**CITY OF ALBUQUERQUE
PLANNING DEPARTMENT
June 4, 2014
DRB Comments**

PROJECT # 1004976

**RE: Black Arroyo Dam - Golf Course Road Vacation/ Subdivision
Design Variance from minimum DPM standards**

EXISTING INFRASTRUCTURE  
**TRACT A-1-A-1**  
**BLACK ARROYO DAM**  
 ALBUQUERQUE, NEW MEXICO  
 APRIL, 2014

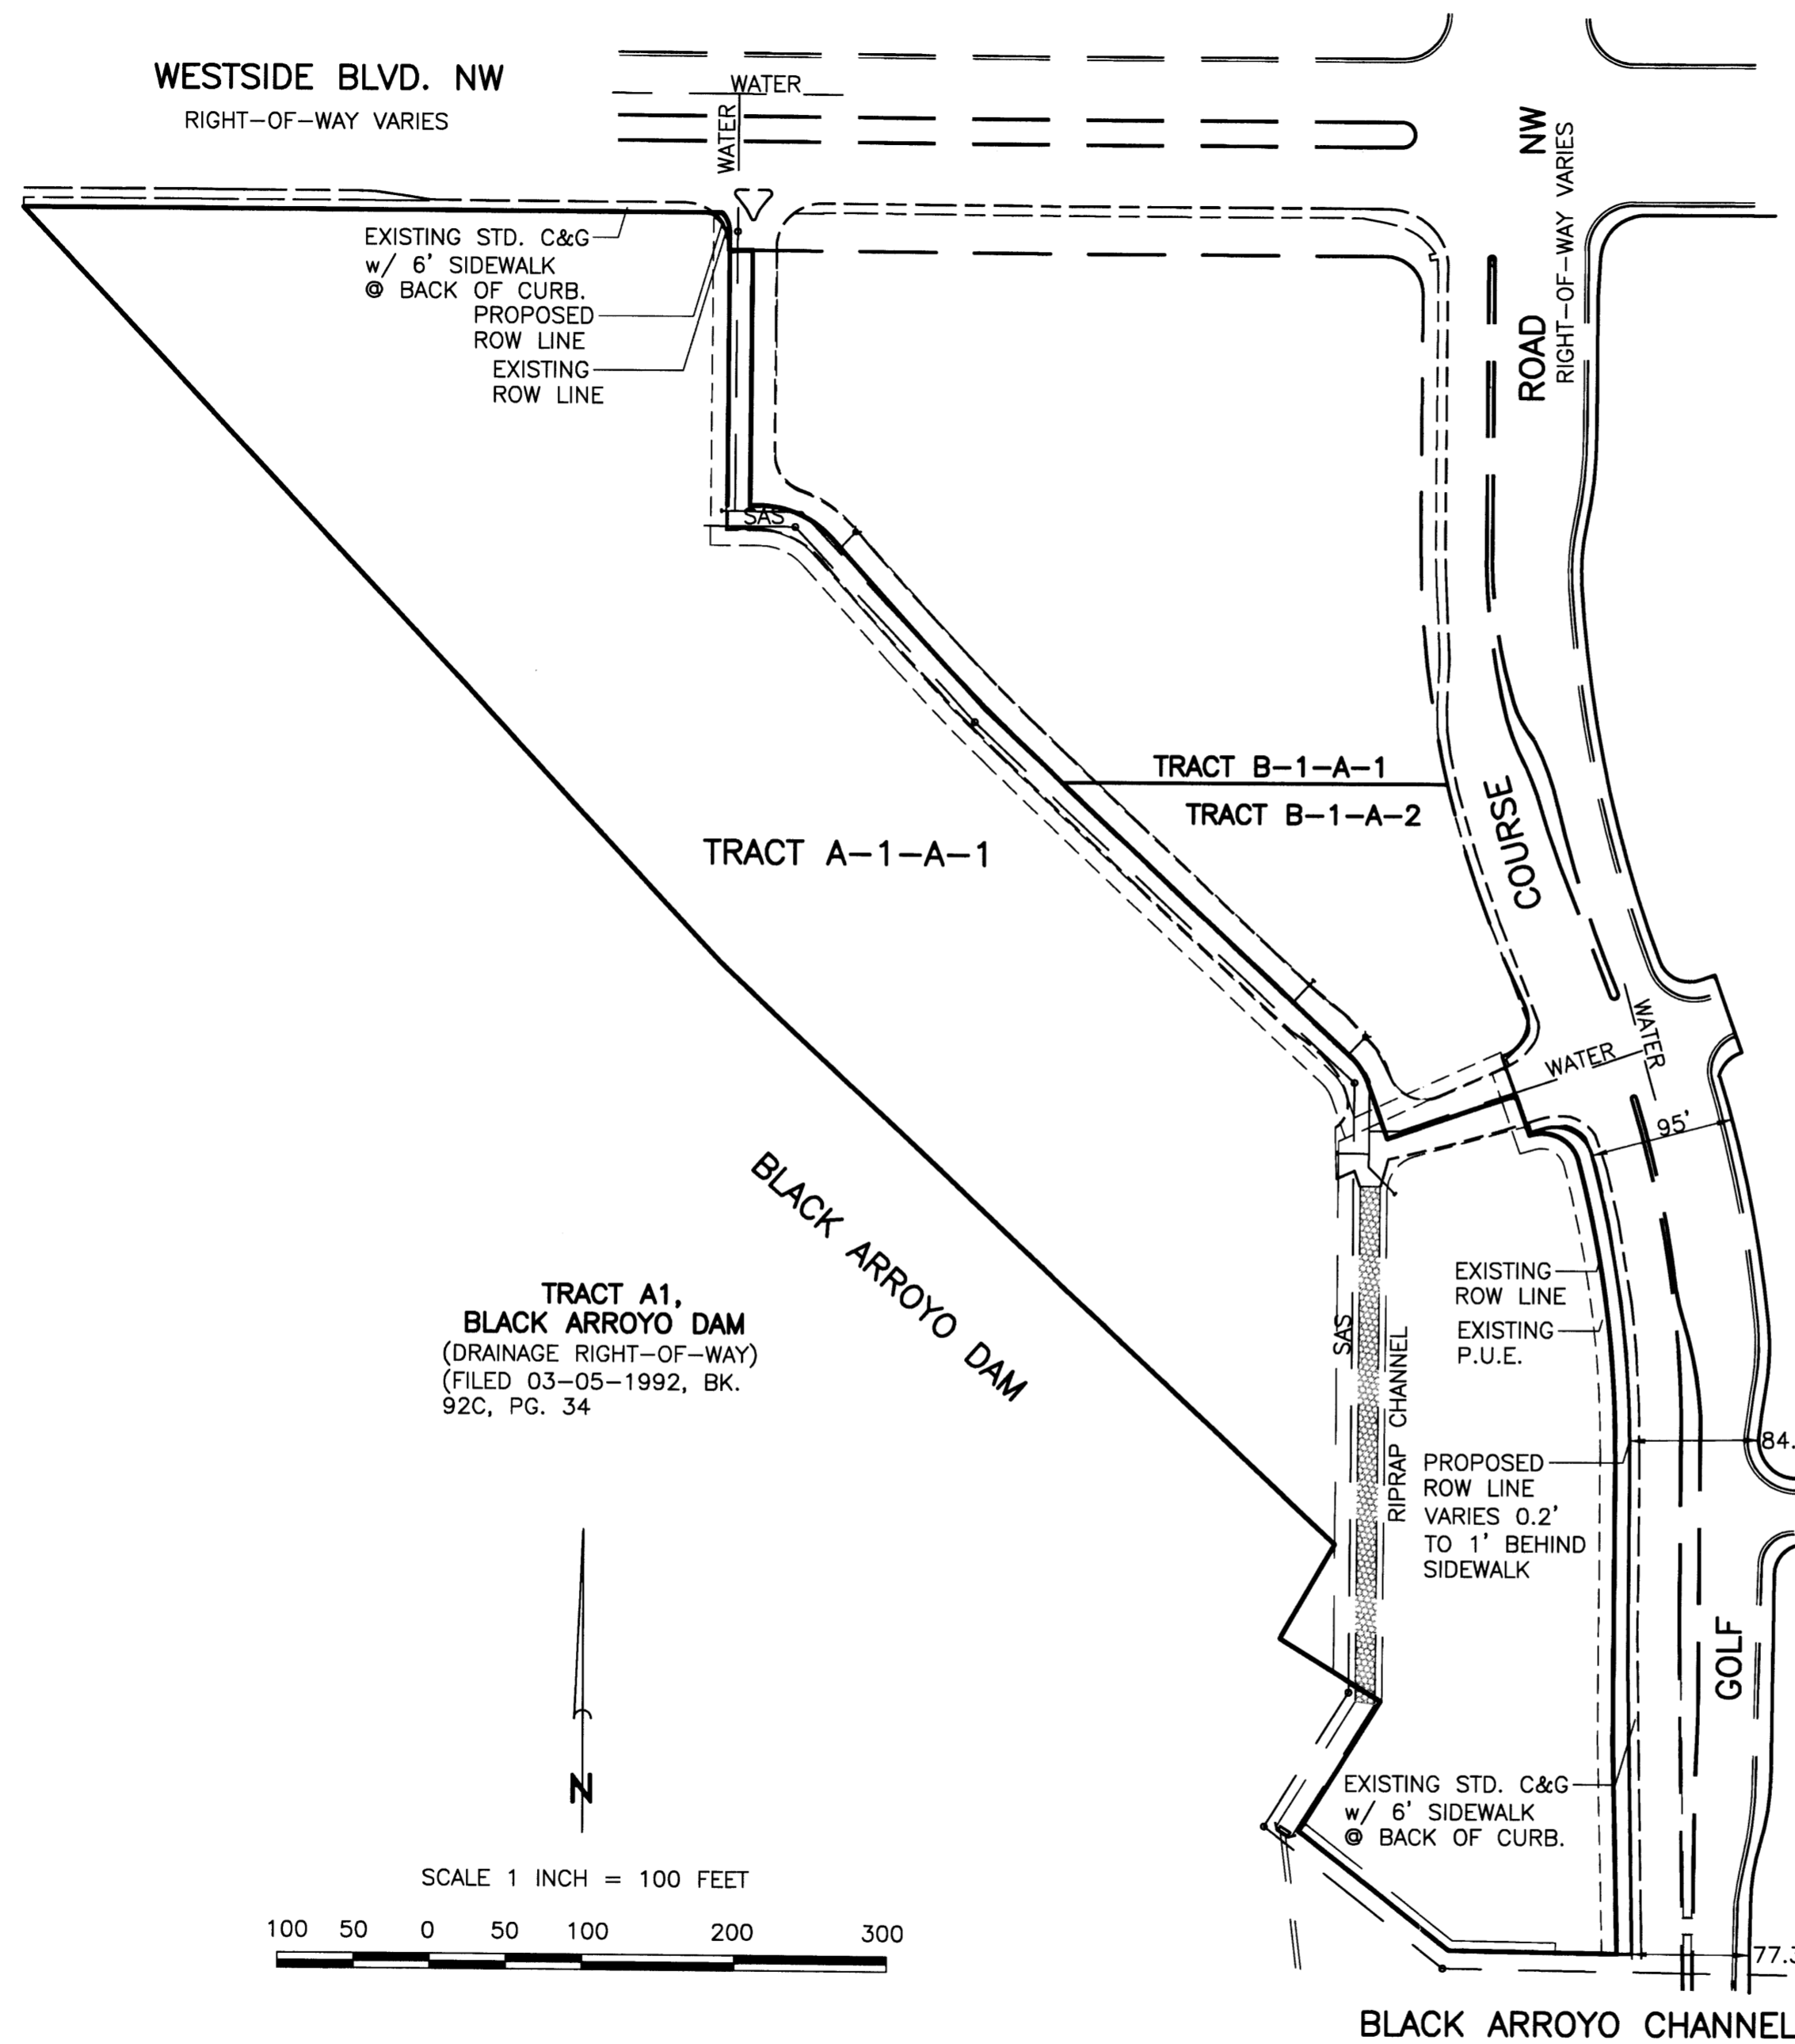
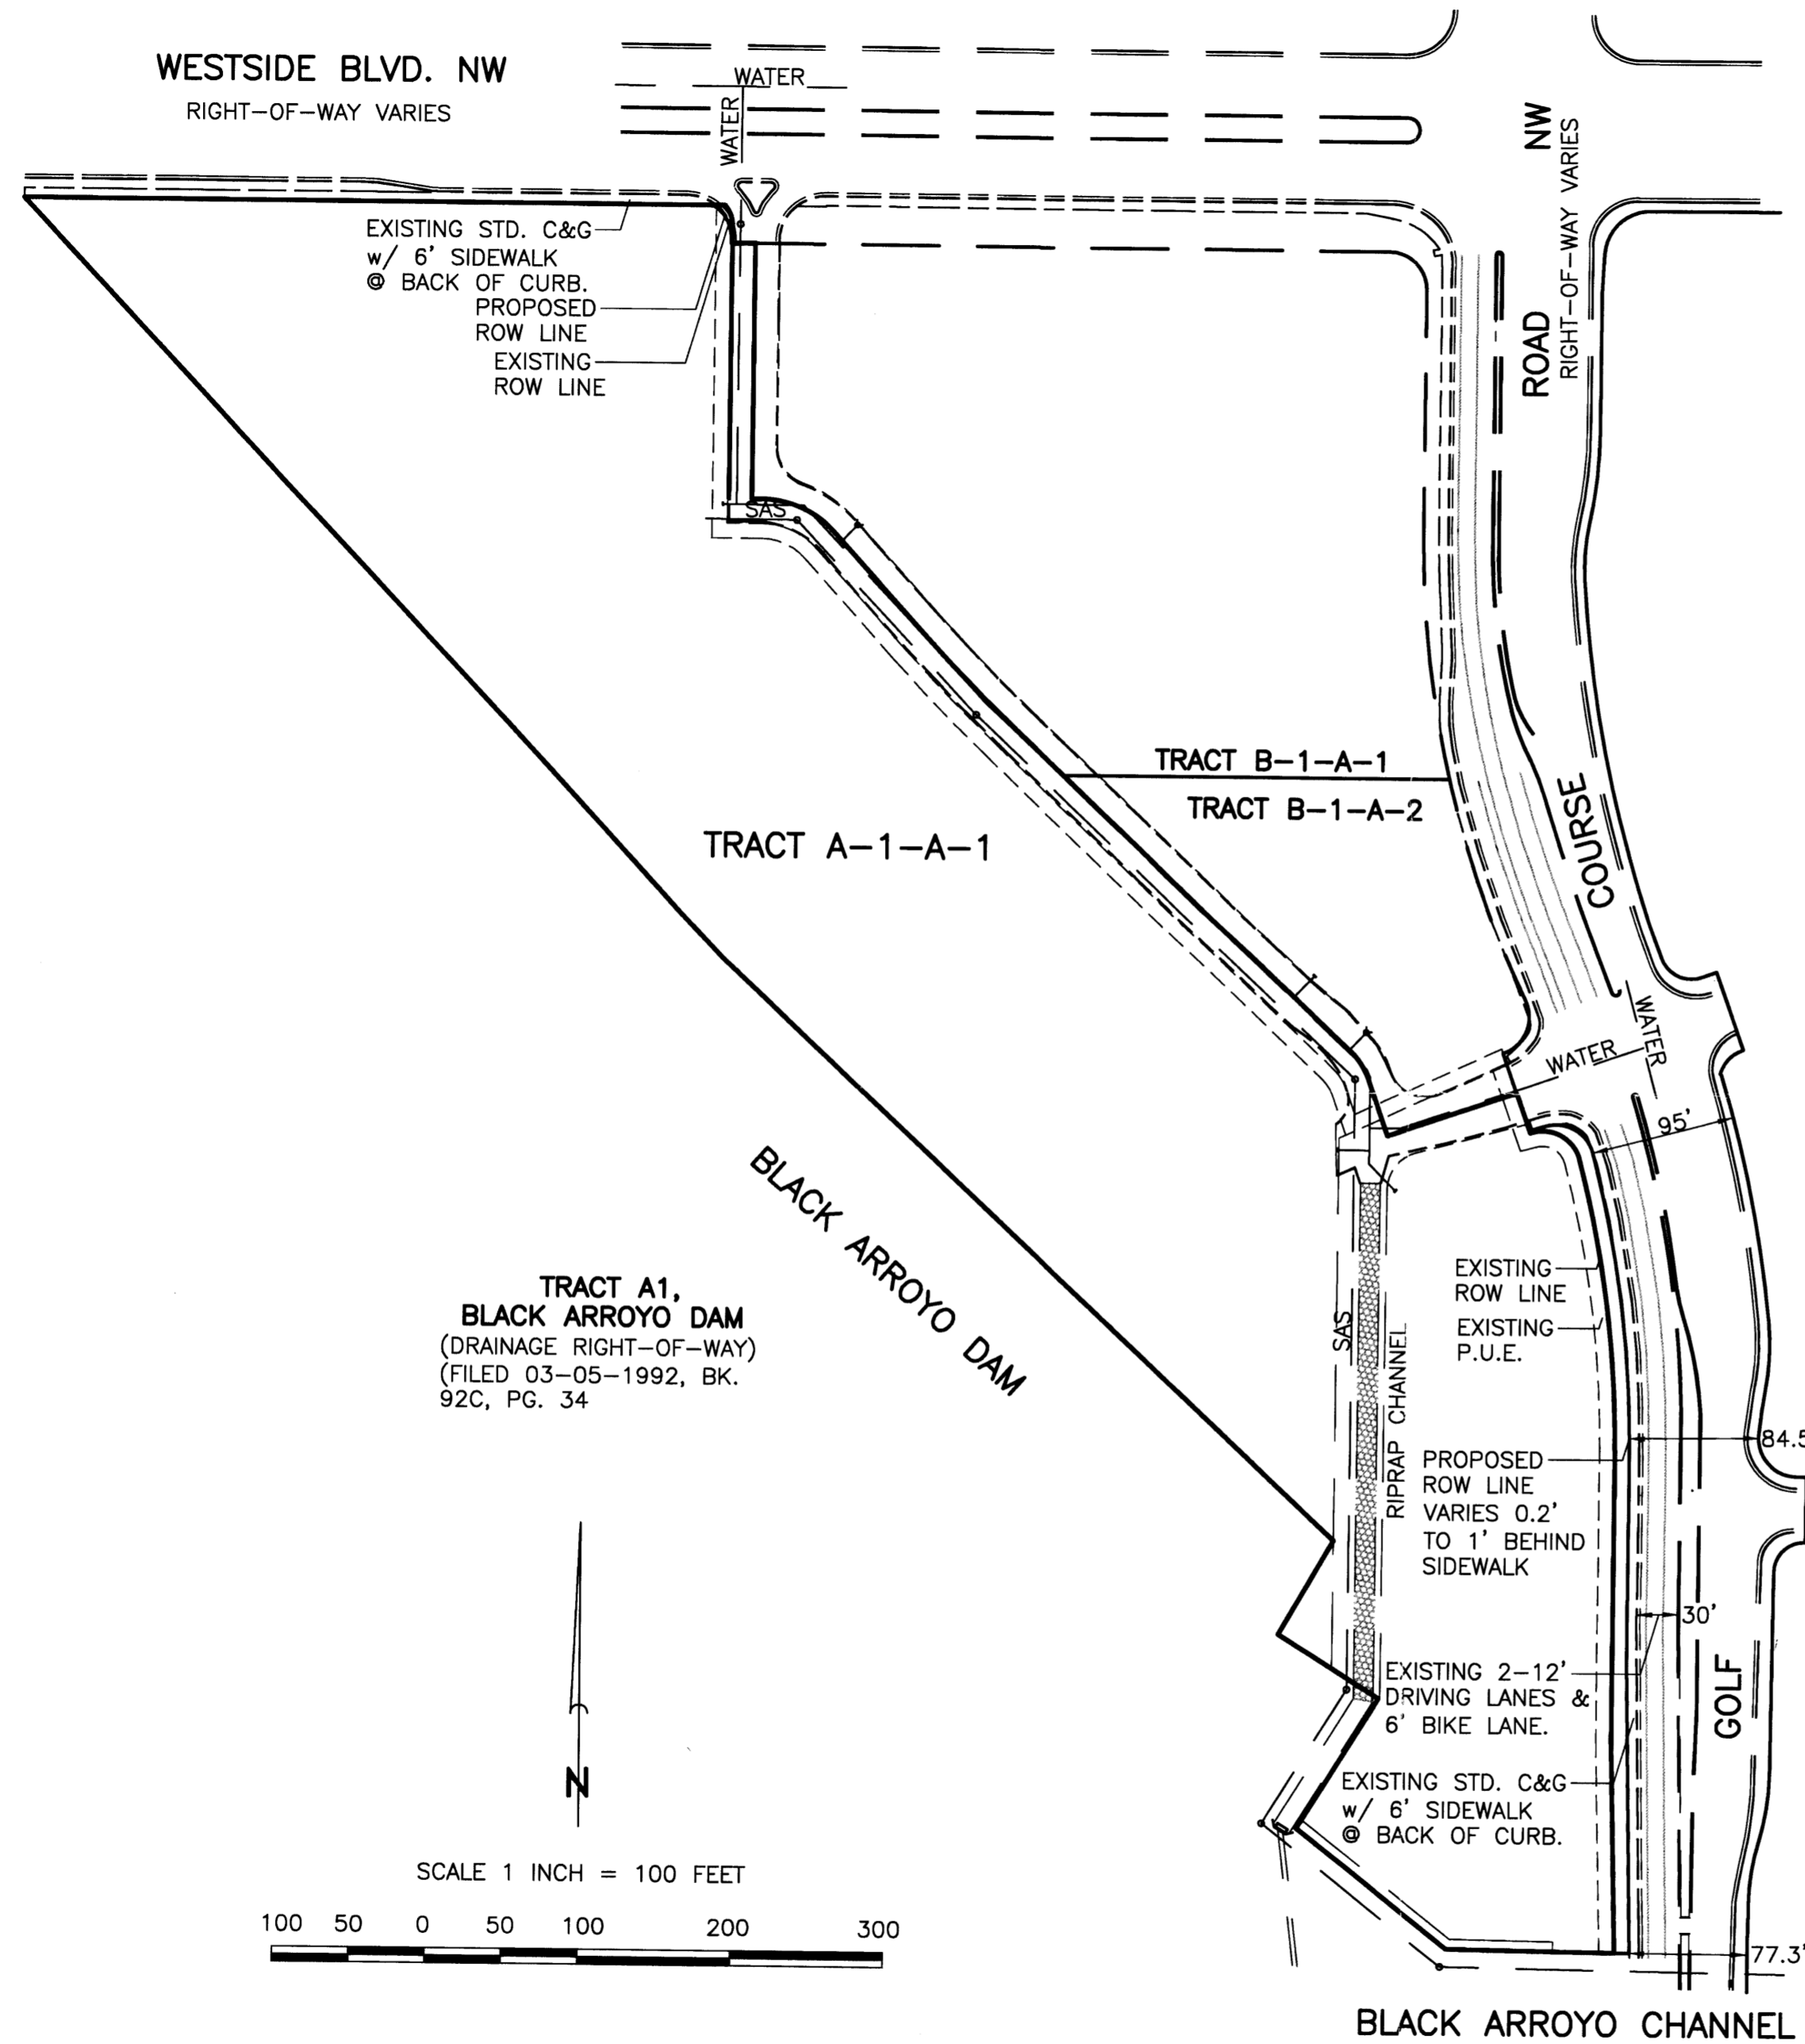
Regarding justification for the proposed vacation, it needs to be demonstrated how the public welfare is in no way served by retaining the right of way. Additional right of way is often provided outside of public improvements for maintenance, emergency access for repairs, etc. and it is unclear how the existing right of way is not needed to serve these public welfare issues. Alternatively, it needs to be demonstrated/ calculated how the development made possible might outweigh the detriment of relinquishing the right of way for the issues previously noted (also see 'Justification for design variance' below). Finally, a review of the file 1002556 does not show a vacation across from the current request but rather a dedication for a deceleration lane (in exchange for vacation to the north). The distance from back of curb to property line was noted as 10 feet; again, this was adjacent to a deceleration lane which is not the same as being adjacent to an arterial travel lane.

Regarding justification for a design variance, it needs to be demonstrated via a site sketch that there is a practical difficulty in providing an internal private roadway which cannot be accomplished with the existing right of way boundary. The property developer will be responsible for landscaping all of the lot's frontage via site development plan approval whether it is in right of way or not.

- 1) Call out dimensions and indicate total R-O-W and pavement widths, both existing and proposed --- the only additional data that was submitted is a partial call out for "EXISTING 2-12' DRIVING LANDES 7 6' BIKE LANE." The necessary exhibit should be devoted to the area in question adjacent to Tract A-1-A-1 and should

include dimensions for the existing plus proposed distances from back of curb to property line, as well as calculate the area proposed for vacation.
